July 28, 2022

**SUBJECT: Monument Academy Subdivision
Response to County Review Comments
MS-21-010**

In conjunction with the re-submittal for this Subdivision, this letter provides responses to the review comments detailed in the Memorandum from PCD-Engineering dated June 1, 2022. These review comments are specifically addressed as follows **(Applicant responses are annotated in bold / red / parenthesis following each County comment):**

# Walker Roundabout North

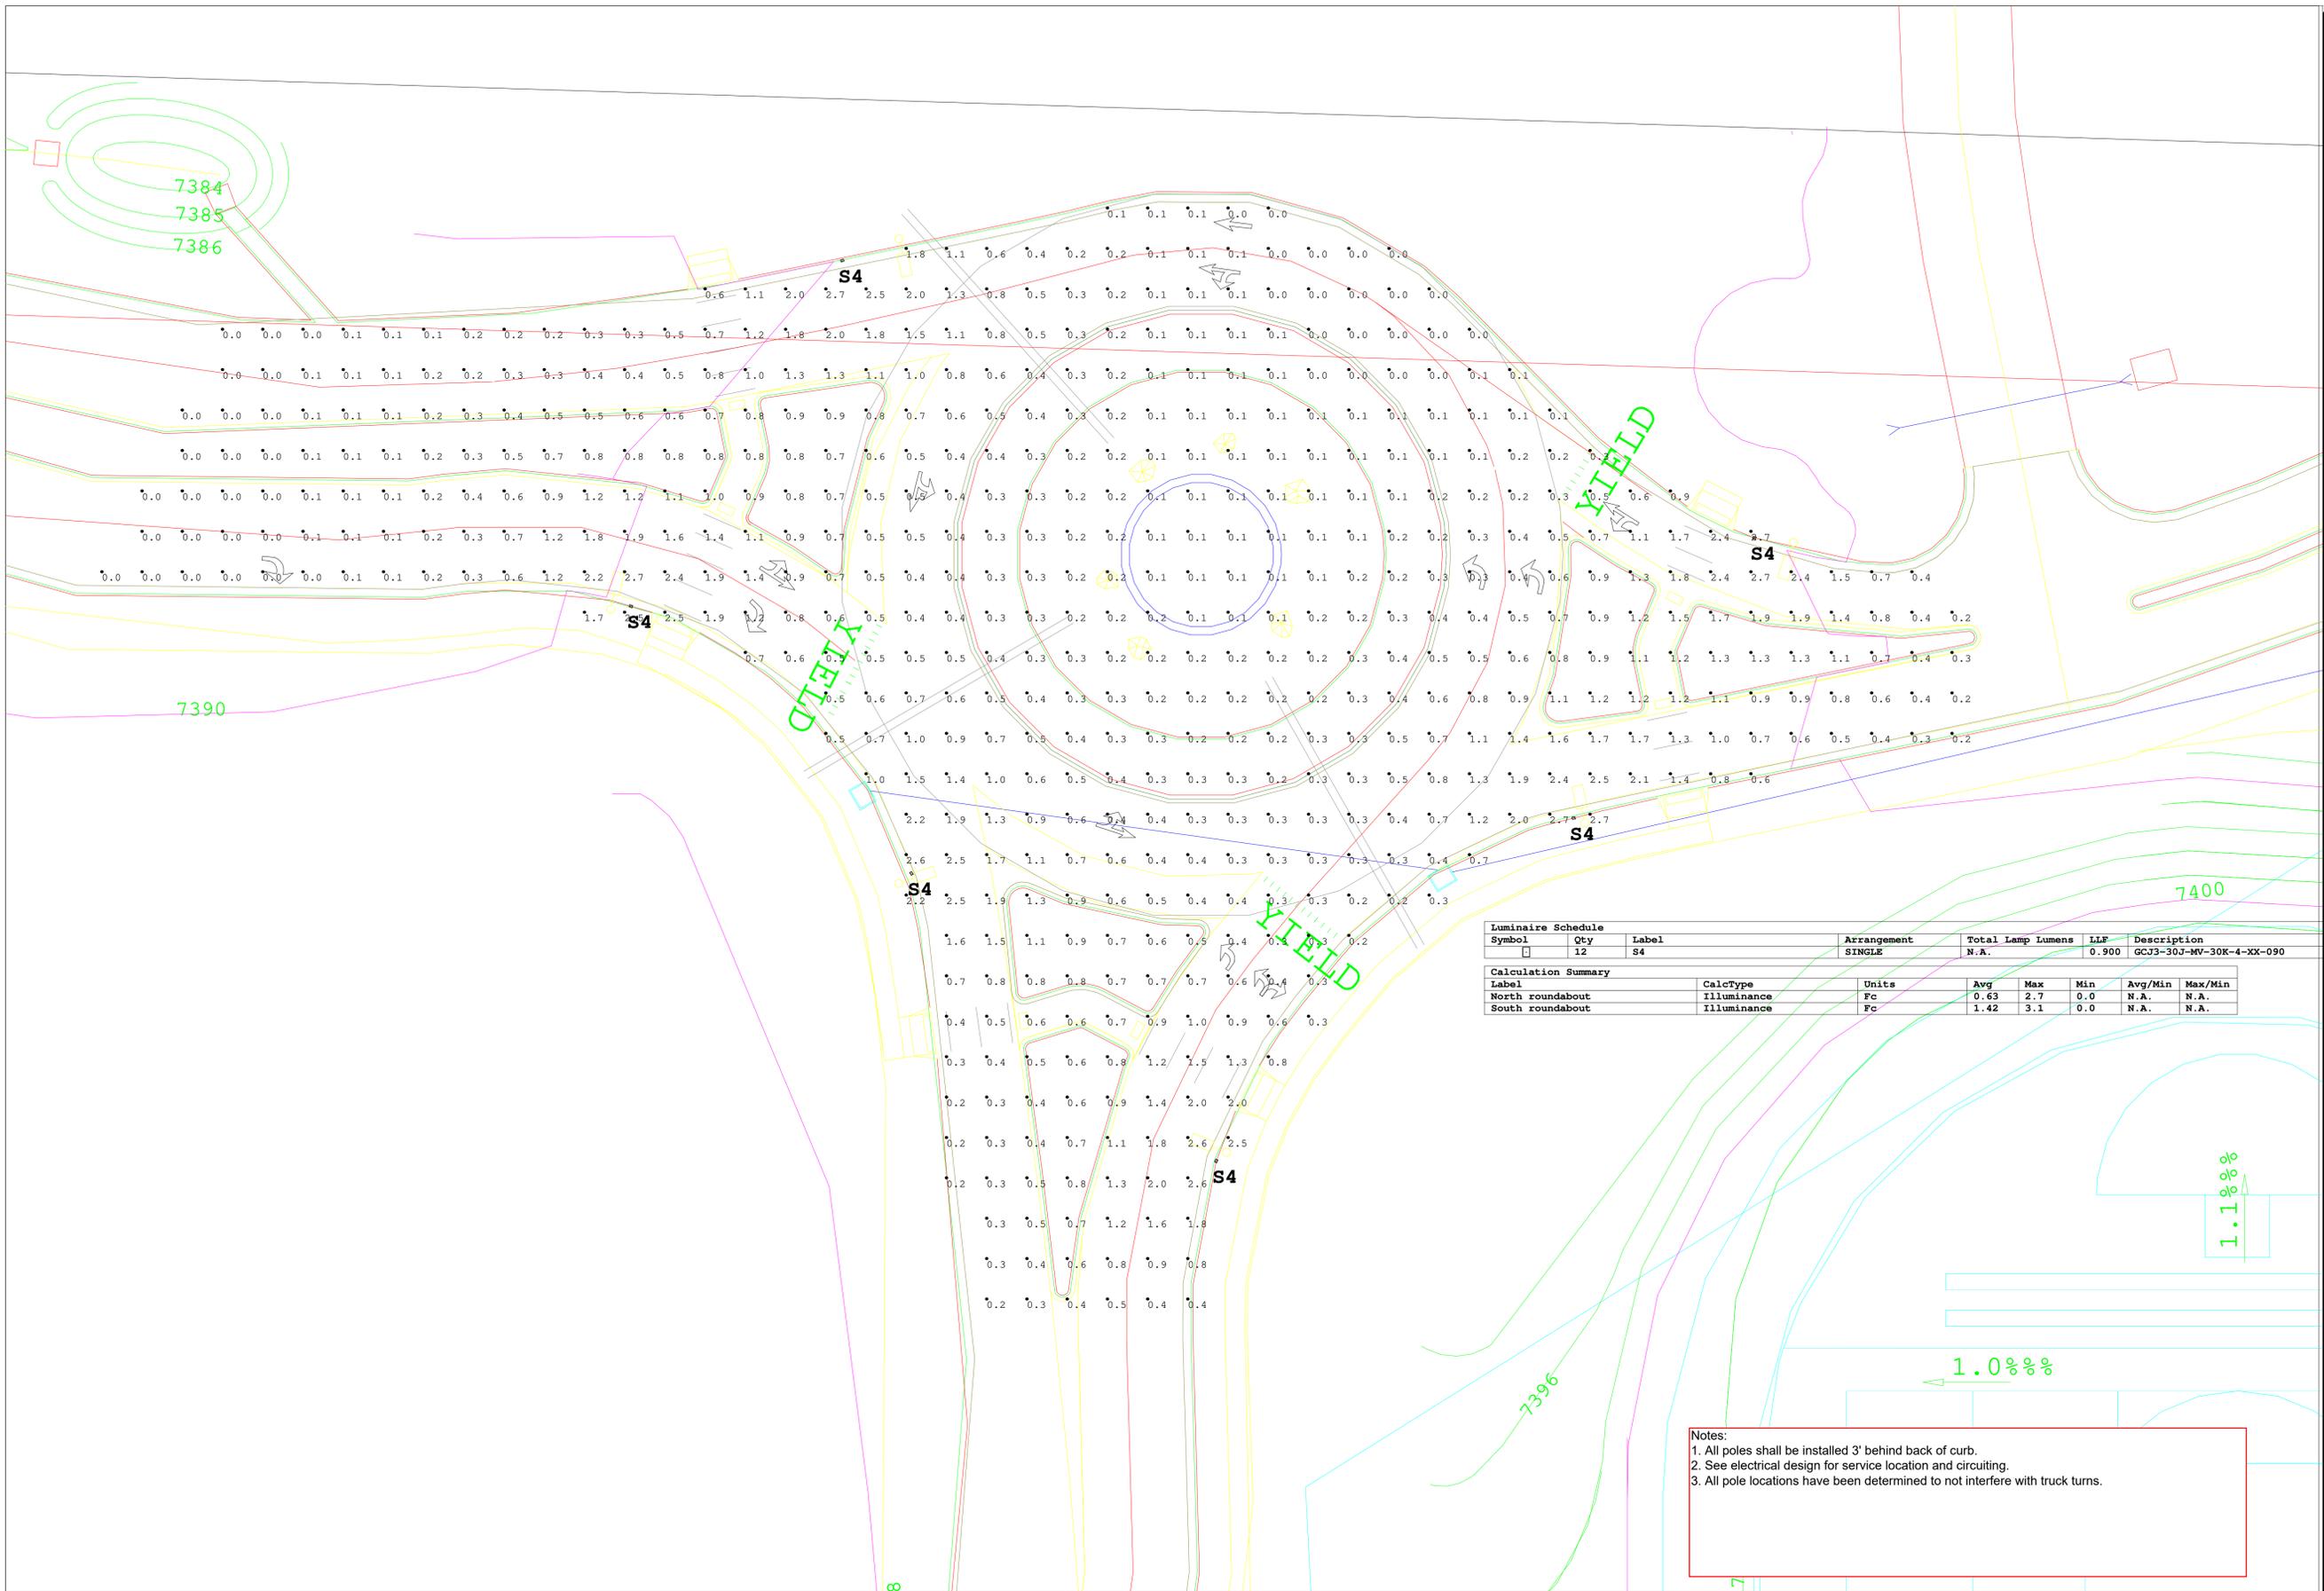
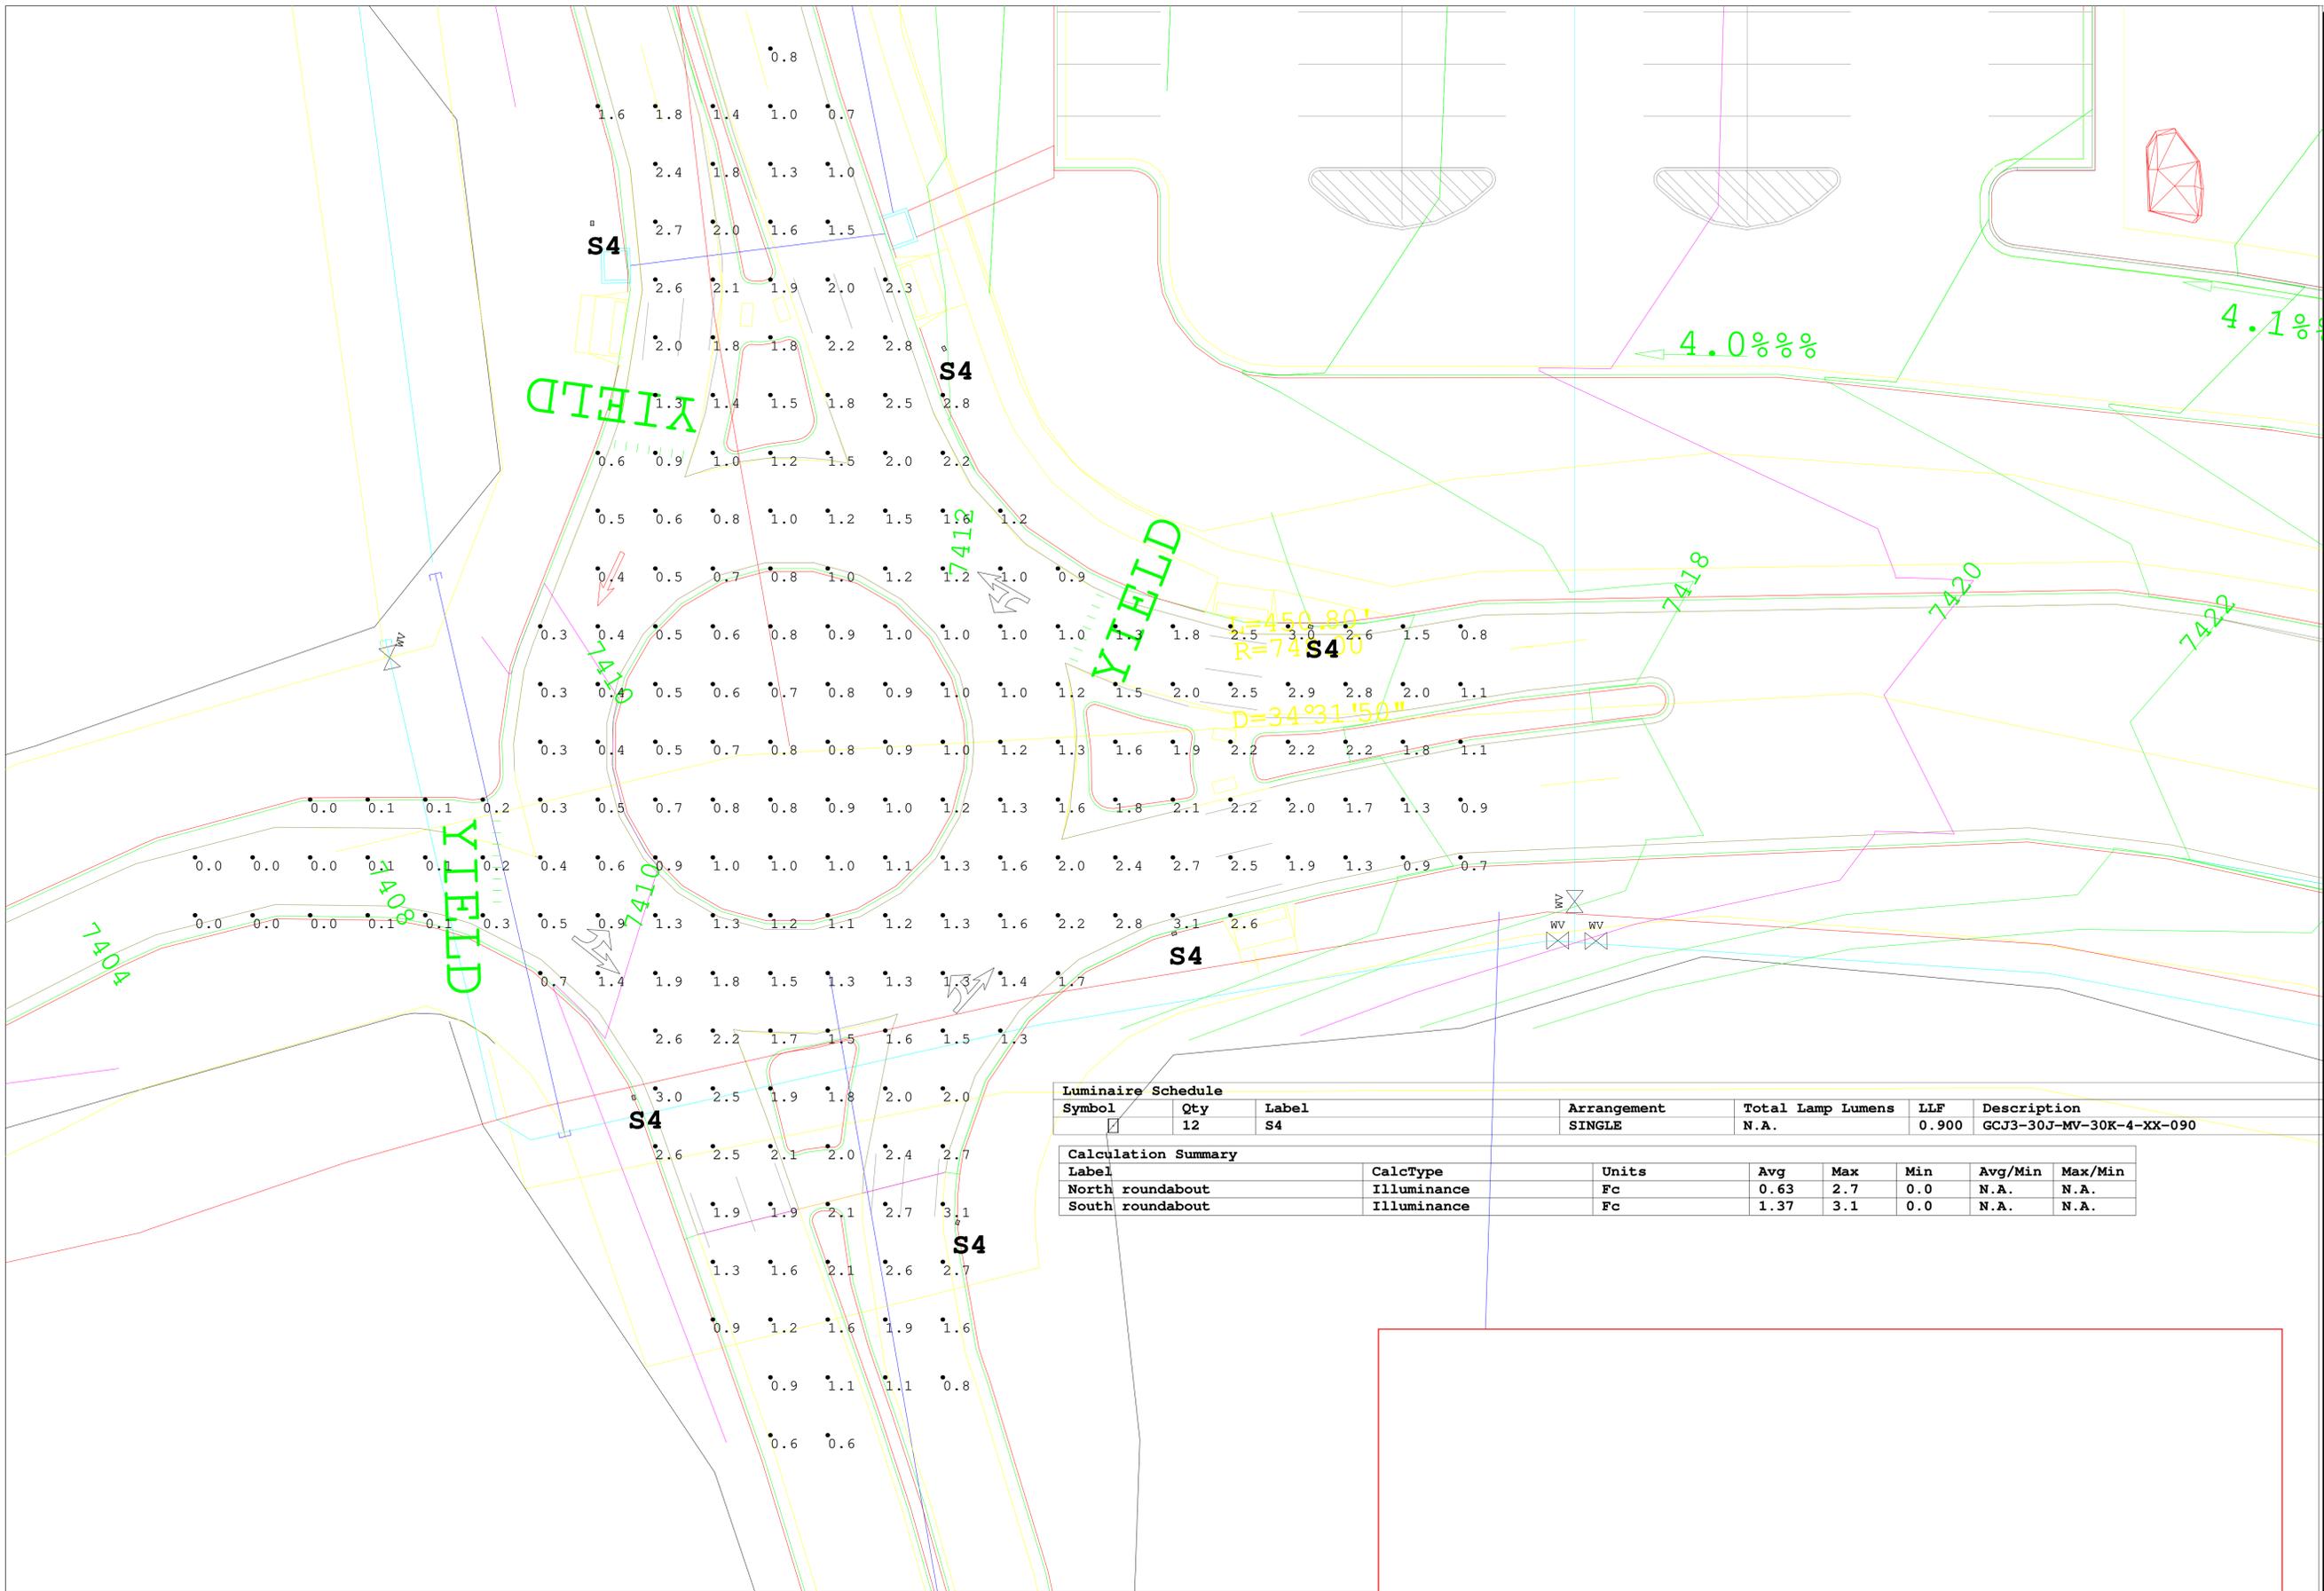
Lighting plans for roundabouts has not been submitted. Please provide with the next submittal. **Partially resolved; the proposed pole locations are generally fine; however, they should be located a distance away from the curb and gutter where WB-50 or WB-67 design vehicle (as appropriate) tracking could encroach on certain locations (per roundabout report). (We have reviewed the LSC roundabout templates and no vehicle tracking is shown beyond the roundabout curbs. Updated Roundabout Plans from Ross Electric note that the poles will be installed 3' off back of curb.)**

EXHIBIT C

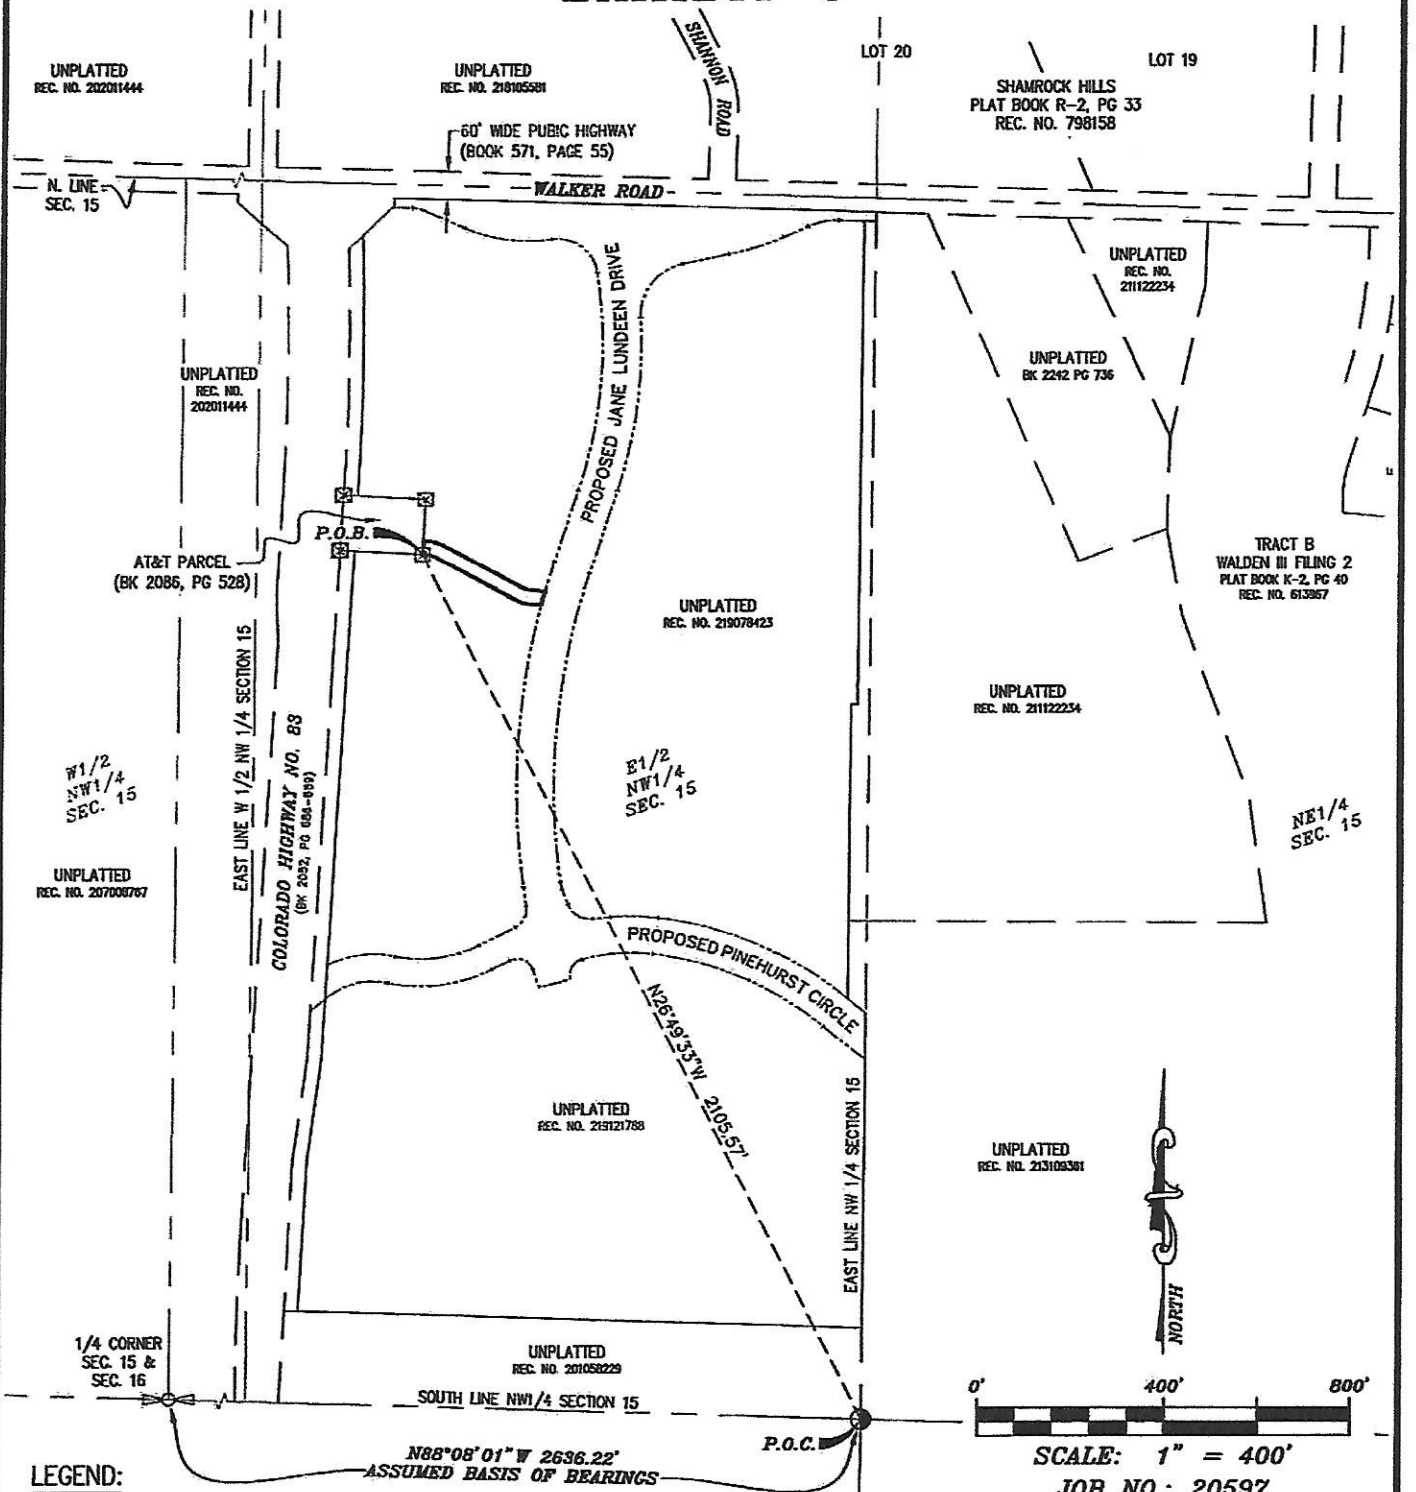
1. Provide a sketch of the new access road to the AT&T facility and any correspondence showing that AT&T finds the proposed easement to be acceptable. **Unresolved. (AT&T access easement has been recorded and graphically depicted on the revised plat, including reception number.)**
